CROSSROADS MIXED USE FILING NO. 2

CONSTRUCTION PLANS

NOVEMBER 2022

STORM SEWER PLANS

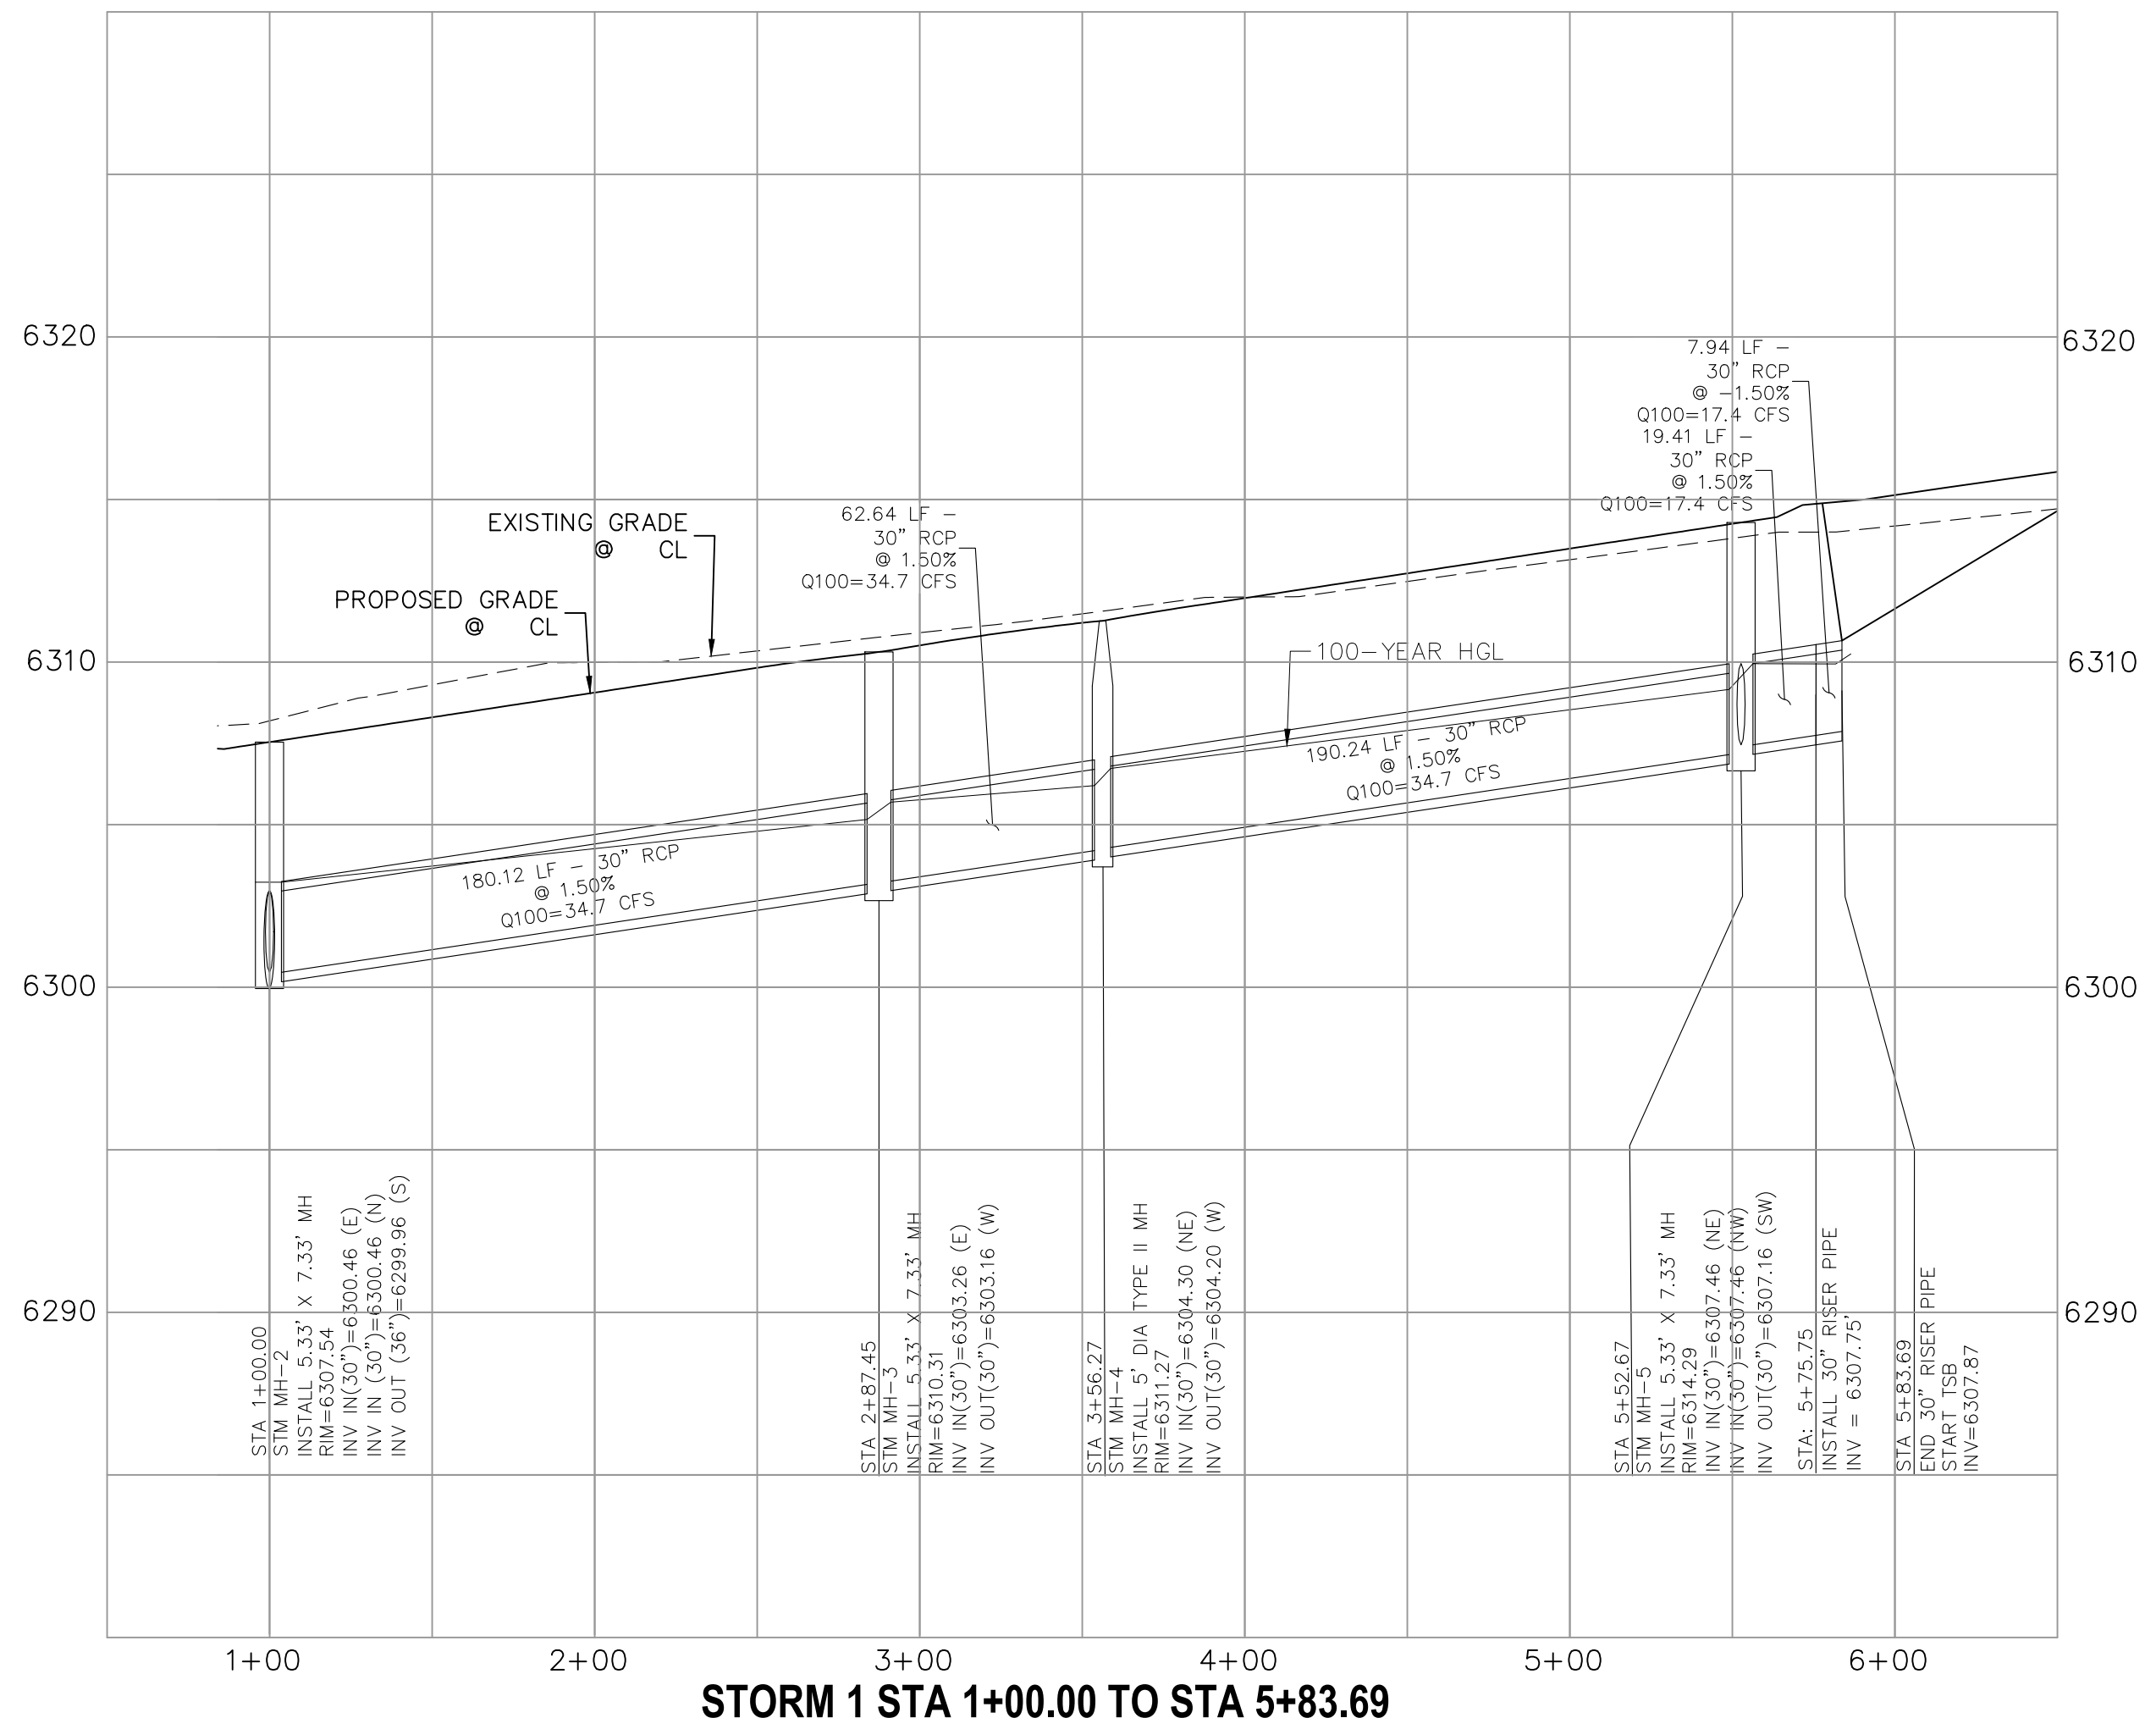
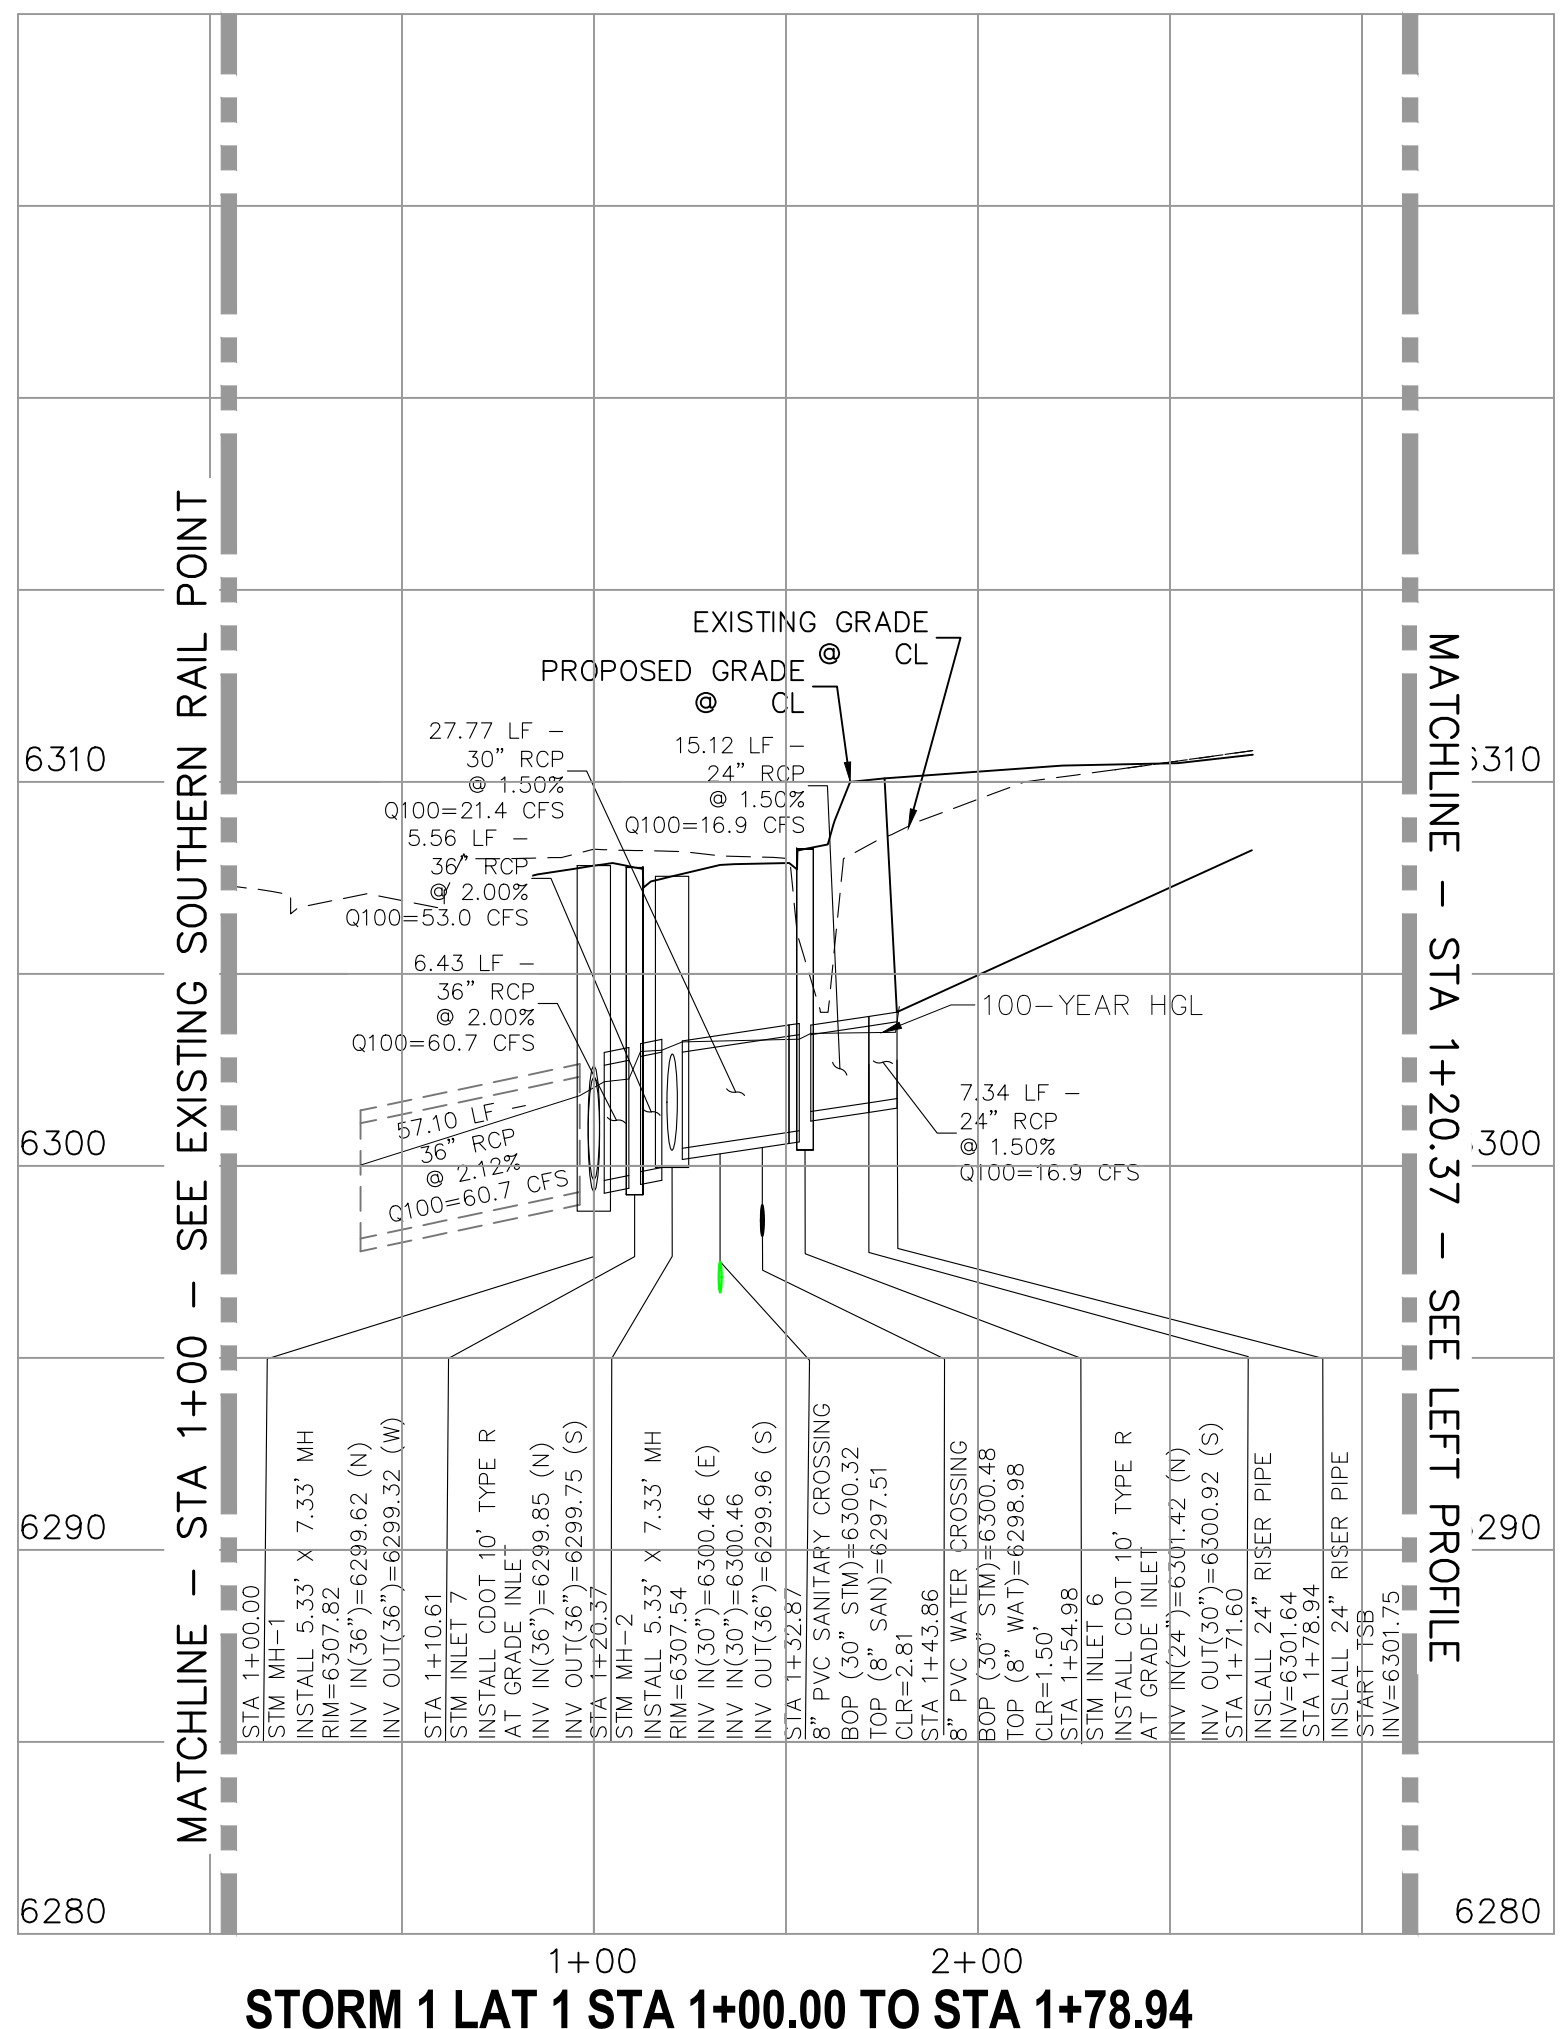
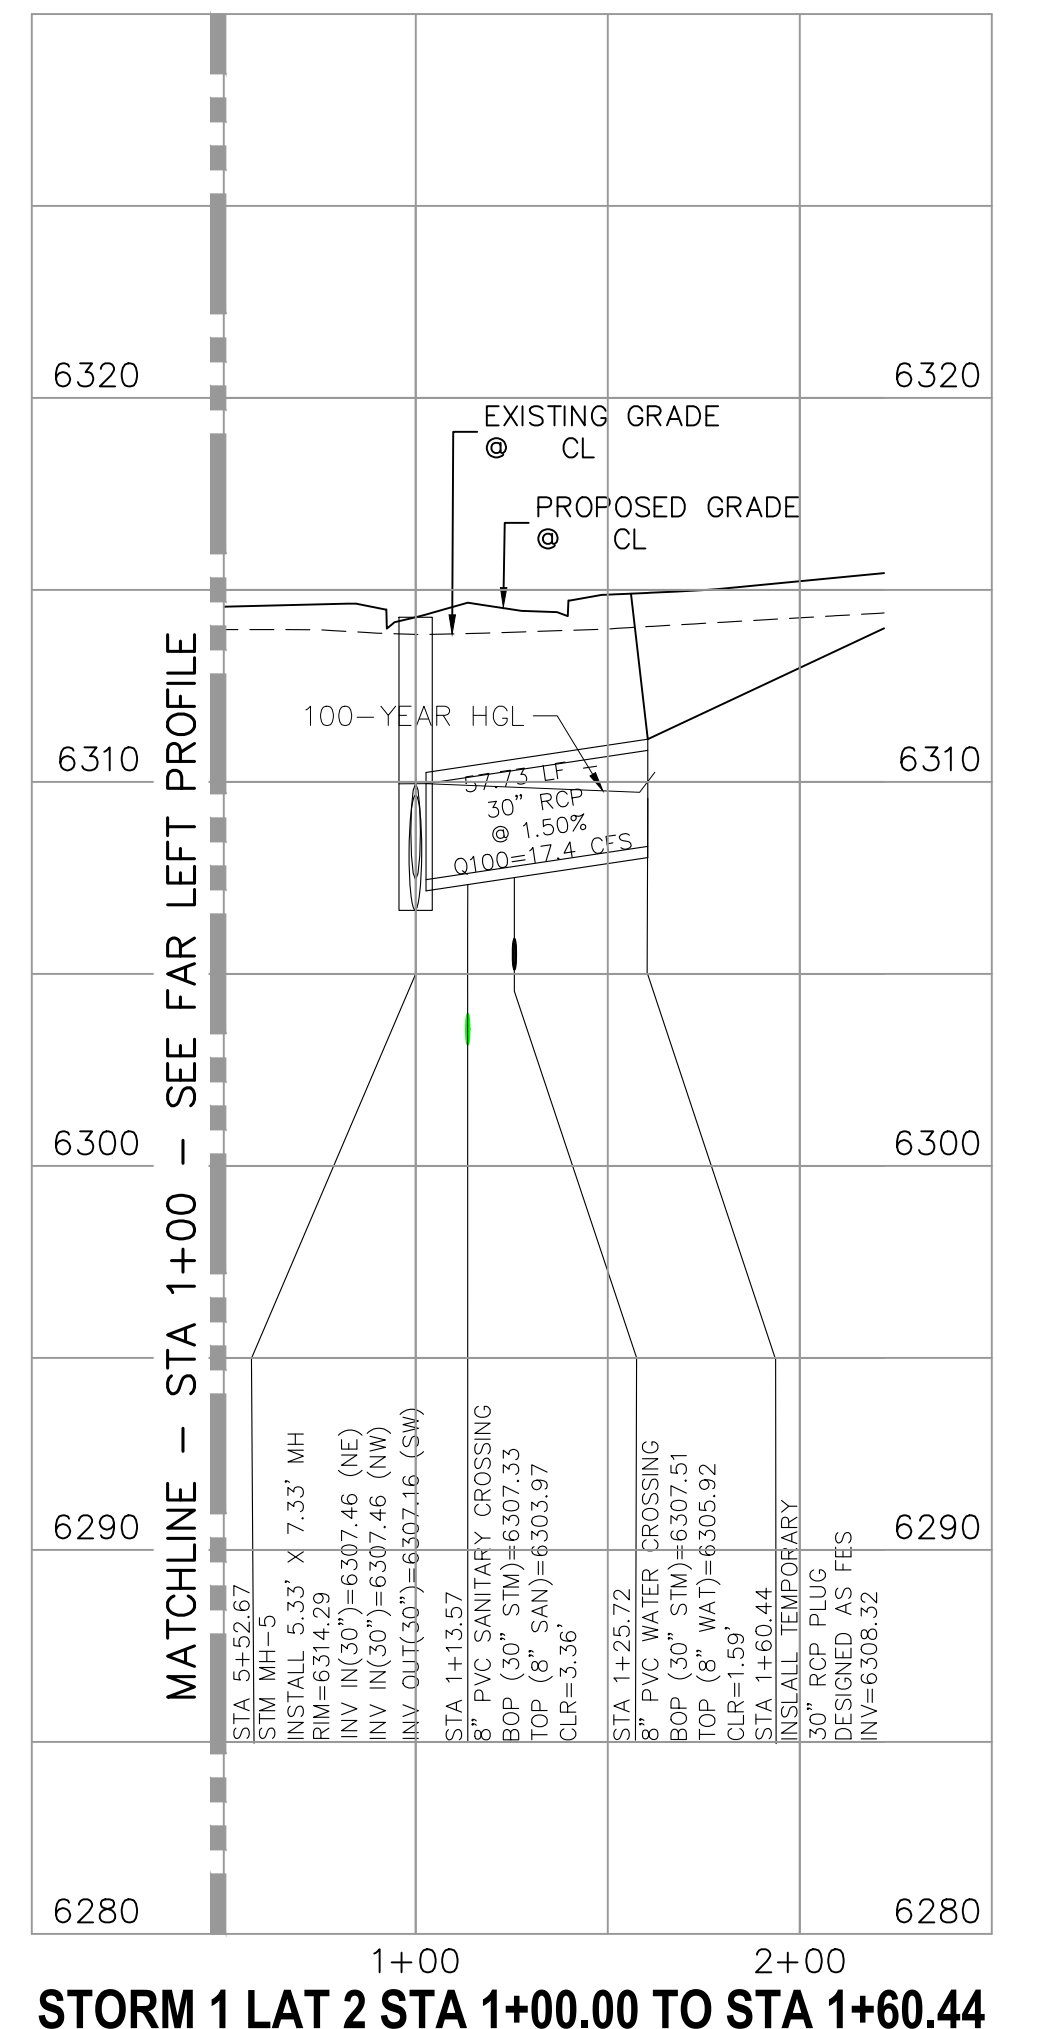
There are several inconsistencies between these drawings and the drainage map proposed conditions. These include: labeling of private and public storm sewer, mismatched pipe sizes, and missing proposed swales. Coordinate with drainage engineer to remove inconsistencies between the two documents.
